Date: 08/14/2025

Re: **Pony Wall Issue**
Location: Lot 72 Tobacco Road (422 Grading Stick Ct. Angier, NC)
JDS Project No.: RDU2508435
Date of Inspection: 08/14/25

Side Load Elevations 'F' (Crawl)

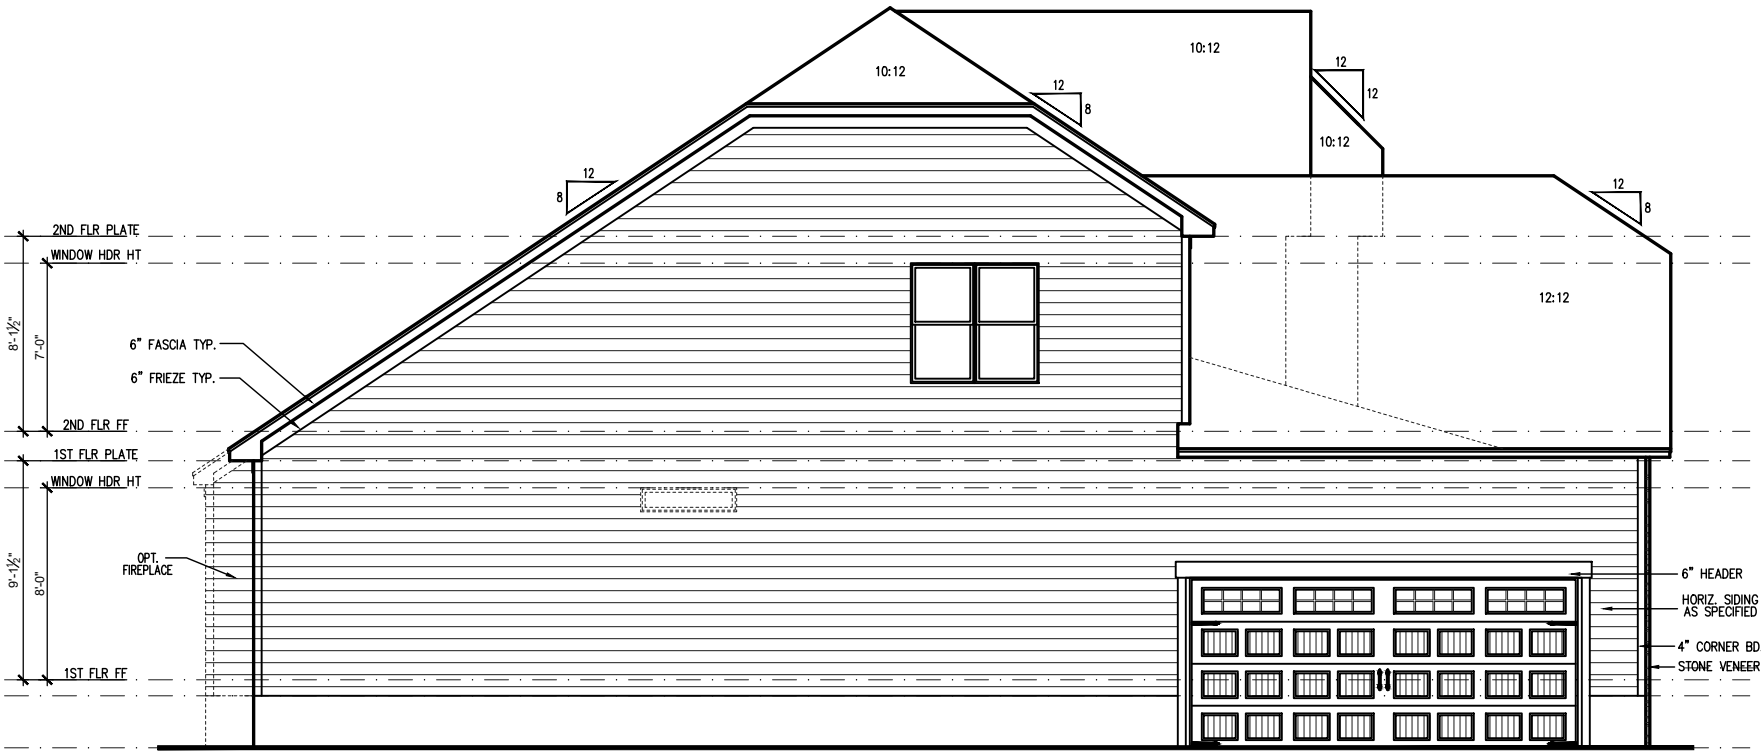
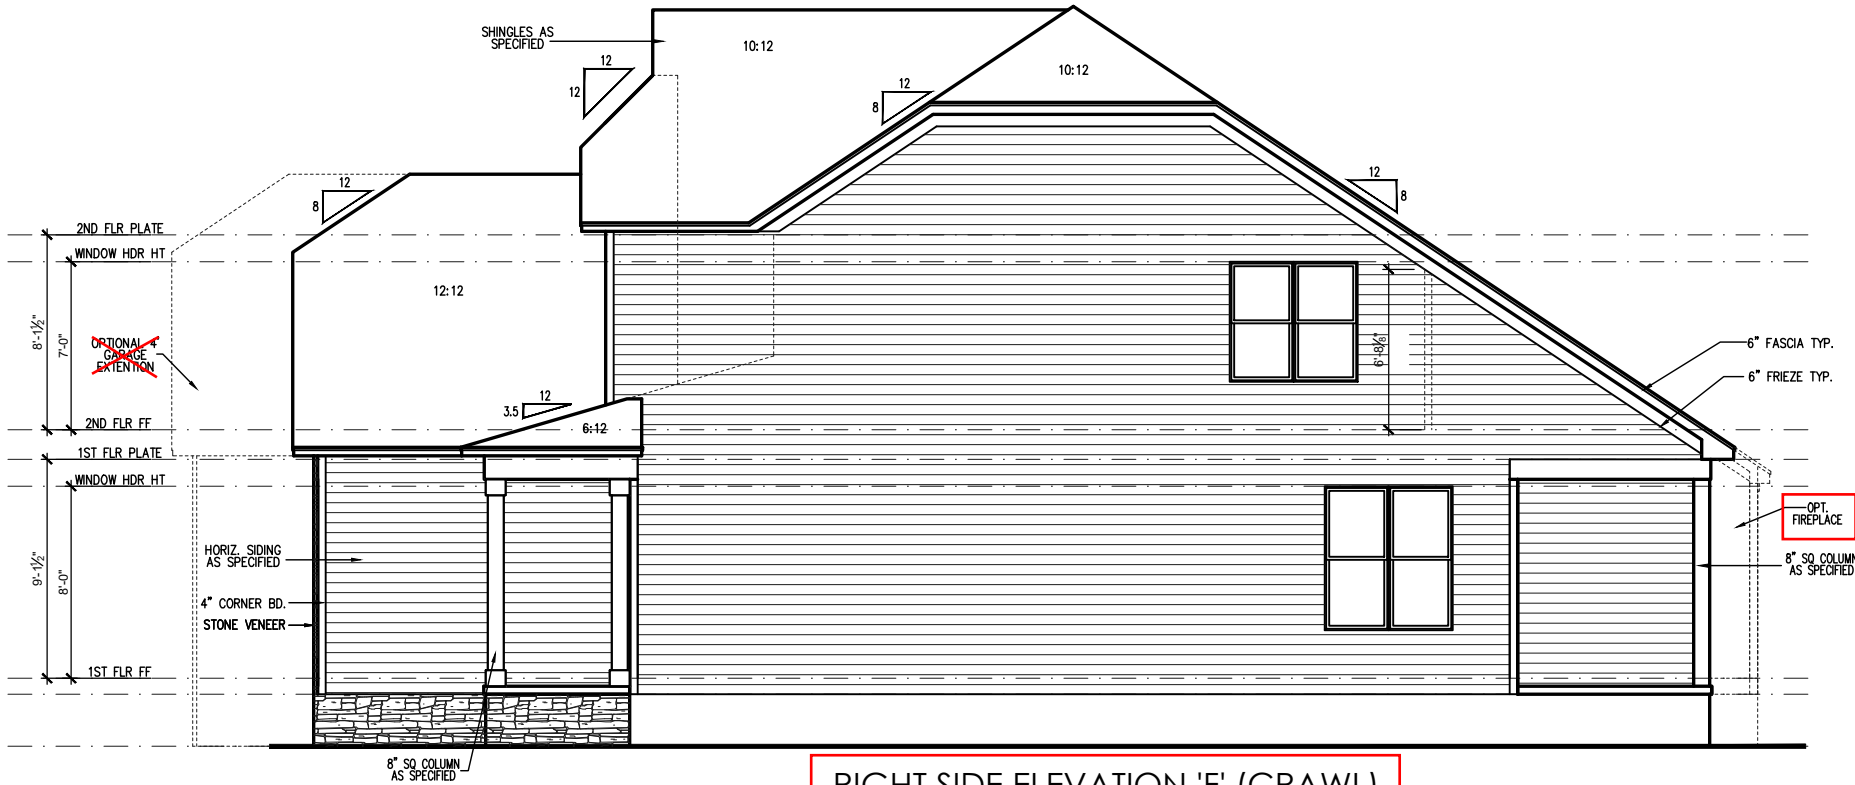
The client requests an evaluation of the garage door pony wall which measures 64" tall. The 2x4 studs are spaced at 16" o.c. along the length of the wall.

Based on our observation and review, CS16 strapping should be installed, inside the garage, at every other stud in the pony wall above the garage door header, from the bottom of the header extending 12" up the stud in the wall above.
